CITY OF ALBUQUERQUE

April 14, 2022

Re: CARMEL APARTMENTS A
7310 Carmel Ave. NE
Traffic Circulation Layout
Architect's Stamp 03-03-2022 (C19-069A)

REVISION	DATE
DATE	3/3/2022
SHEET NUMBER	AS-1.0

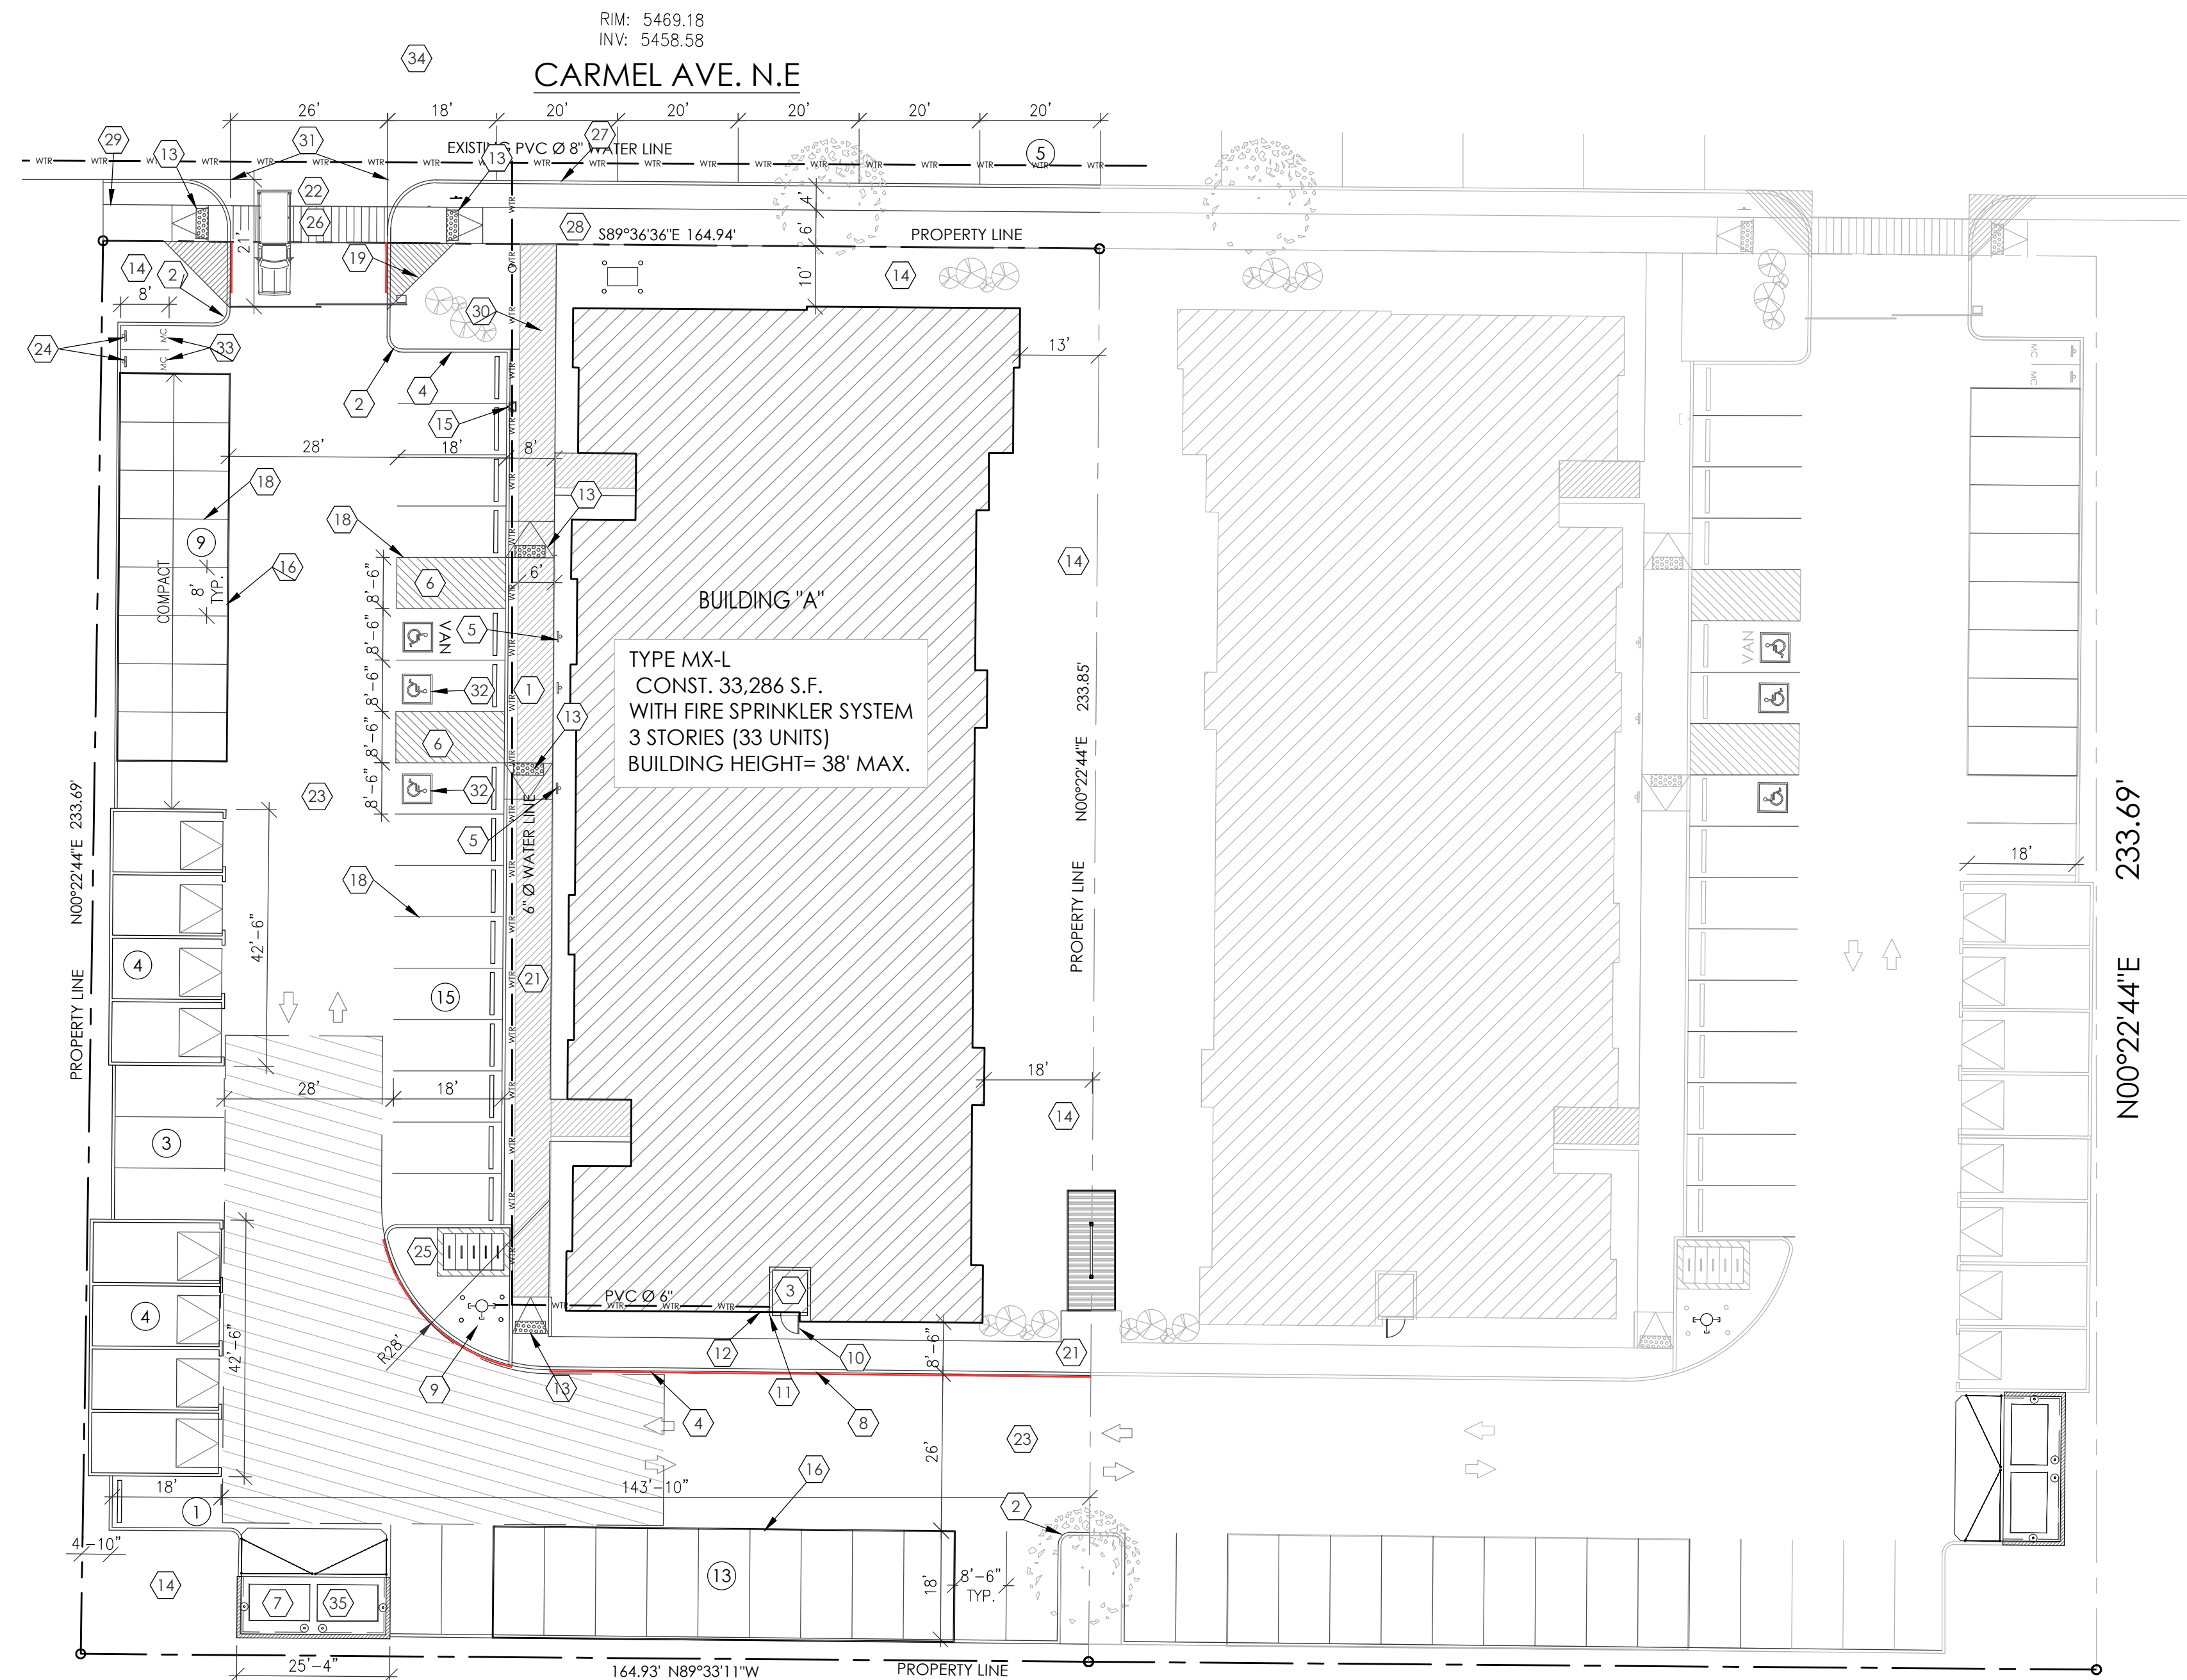
- **Keyed Note 22:** Change notation from drivepad to driveway and show the 6 ft valley gutter as part of the entrance drawing.
 - **Keyed Note 26:** Proposed cross pathway striping will need detail for striping.

- **Keyed Note 28:** Provide a tie-in grade of 5:1 back to existing surface elevation at end of sidewalk.

- **Keyed Note 29:** Reference COA std dwg 2430 for sidewalk detail and provide a tie-in grade of 5:1 back to existing surface elevation at end of sidewalk.

- **Keyed Note 34:** Nope, remove this note.
3. An secondary emergency access will need to be provided as part of this proposed development and a temporary paved connection back to Carmel Ave will be needed as part of the TCL requirement.

4. **Keyed Note 1:** Reference A8/AS-2.0 instead of A10.
 5. **Keyed Note 13:** Reference either detail A8 or A10 on sheet AS-2.0 for proposed ramp.
 6. **Keyed Note 21 & 30:** Reference A5/AS-2.0.

9. **Detail A10:** 50:1 and 12:1 should have the word max. after each text.
 10. **ADA Parking Access Aisle dimensions (on site plan):** You specify 8'-6" on layout but on detail you call out 8'-0". Please address this concern.

11. **Proposed Compact parking stalls:** Provide stall lengths for compact parking stalls.
 12. You have a hatch area/segment of pavement around the drive aisle located at the corner back of the proposed building and no legend to define this hatching. Please provide some type of note to define this hatching.

13. Identify the **right of way width**, medians, curb cuts, and **street width** on Carmel Ave.
 14. Clarify proposed property lines since an approved Plan was not provided.

18. Label the compact parking spaces by placing the words "**COMPACT**" on the pavement of each space.
19. The ADA accessible spaces must include an access aisle. Van accessible aisles should be **8ft wide**; all others should be 5ft wide.

20. **Motorcycle parking spaces:** Provide stall widths.
21. Provide a copy of refuse approval.
22. Fire Department: An approval Fire 1 plan needs to be provided.

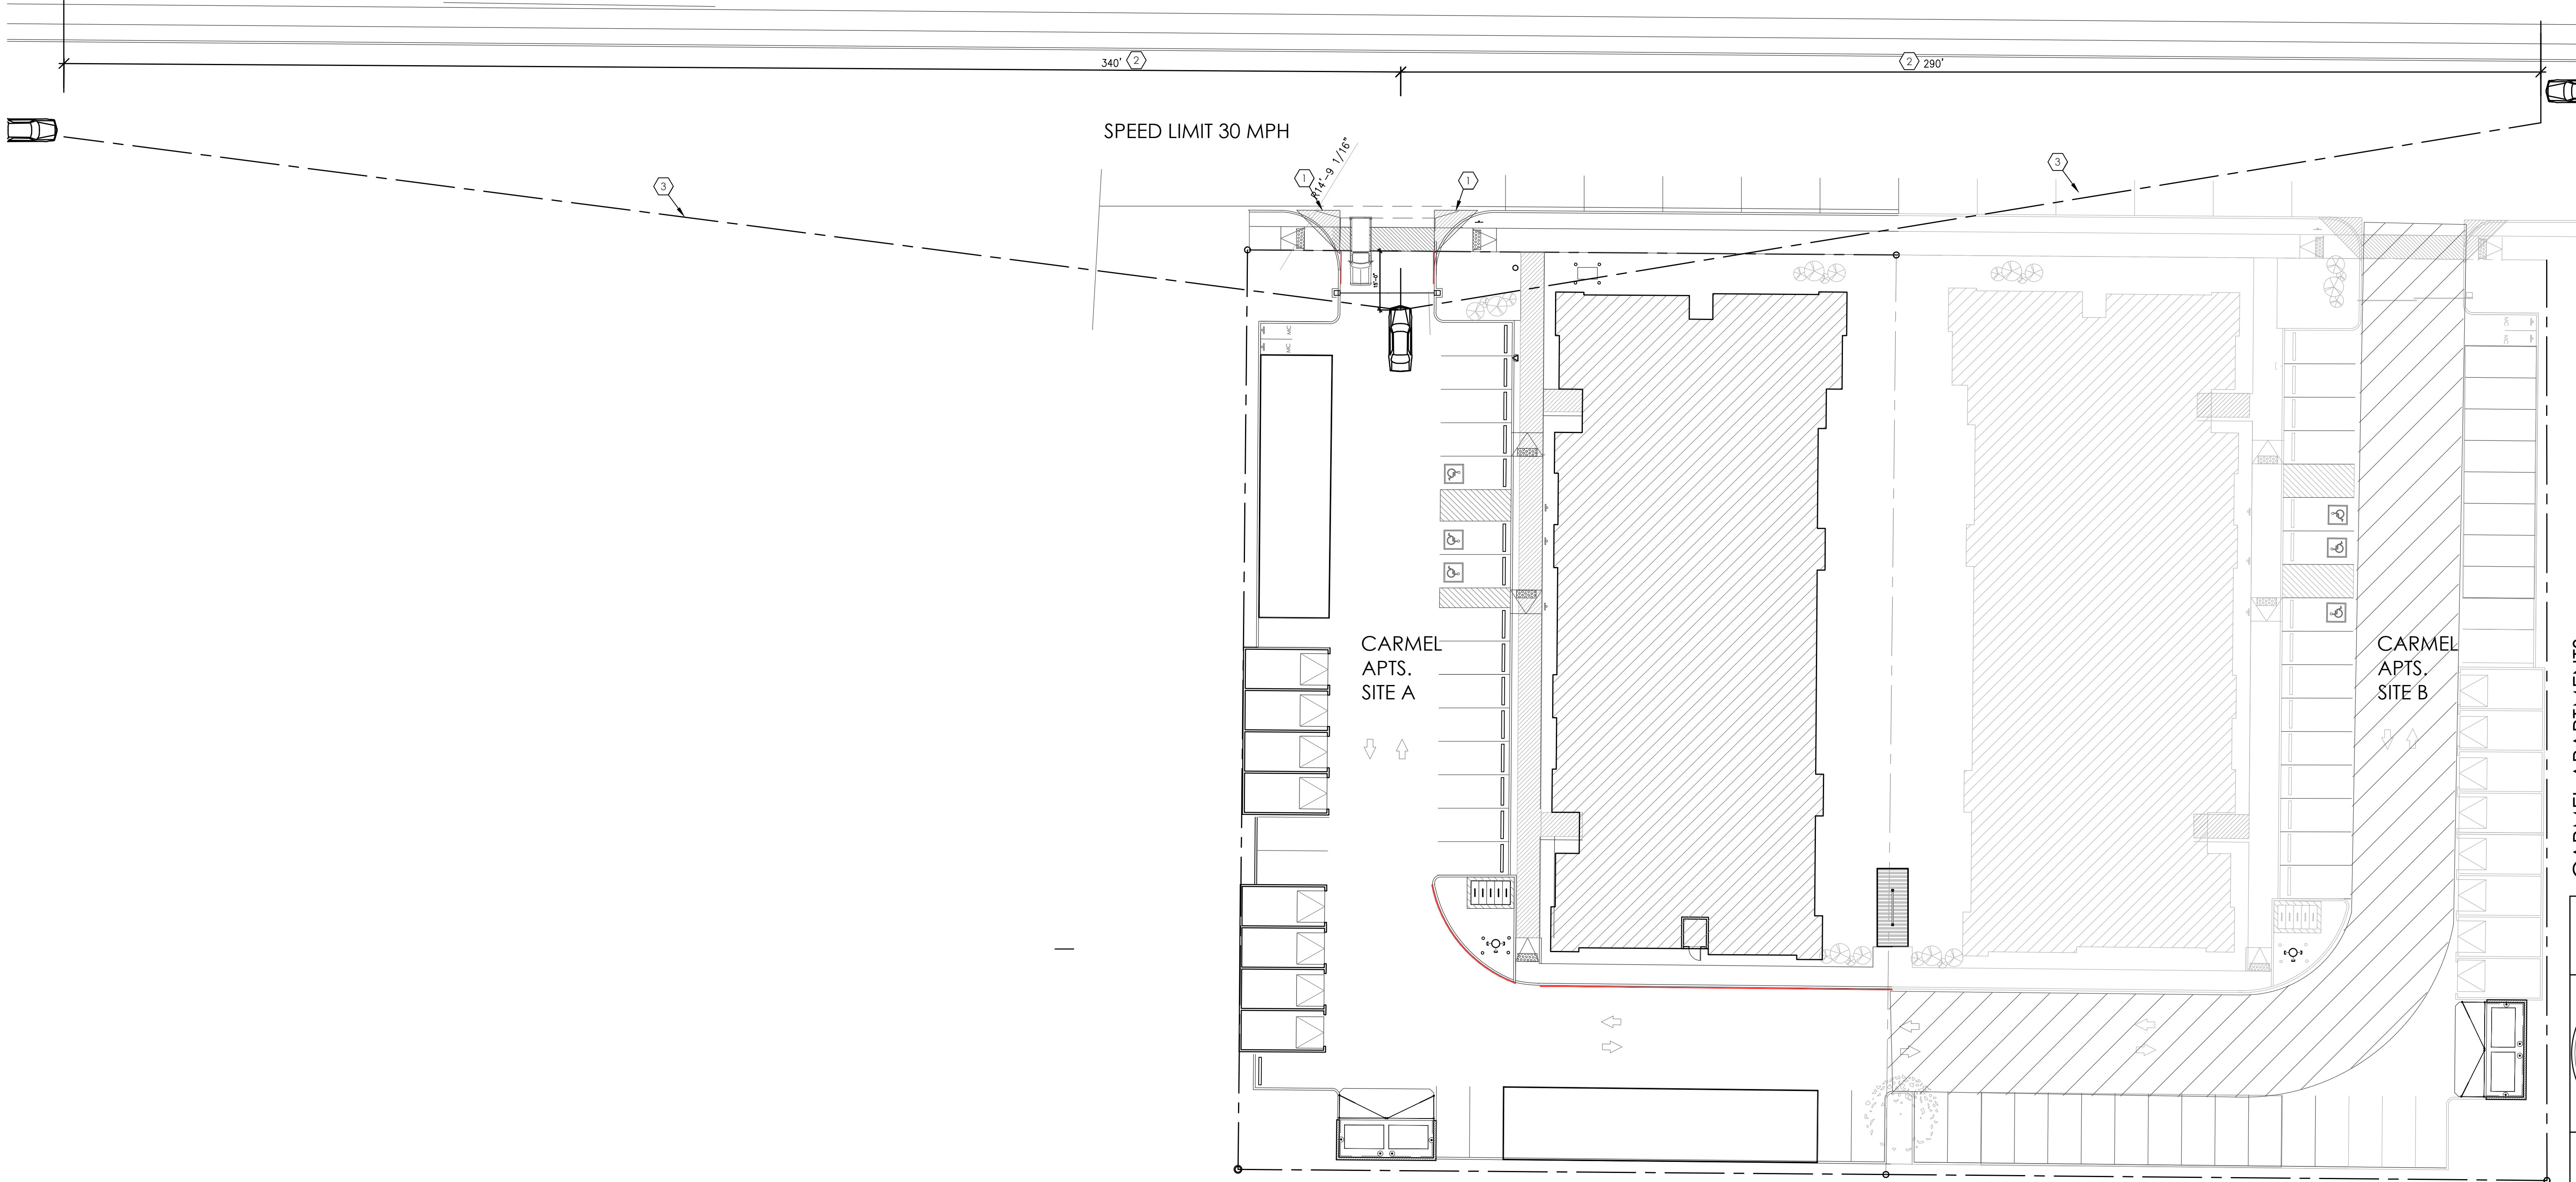
- From above, pick which one will apply to this concern of Carmel's missing roadway portion.
 - It appears that you are proposing onstreet parking. Please coordinate with Traffic Operations on the striping or remove striping. You will need a **clear site line exhibit** since onstreet parking is being proposed and might possibly block stopping site distance.
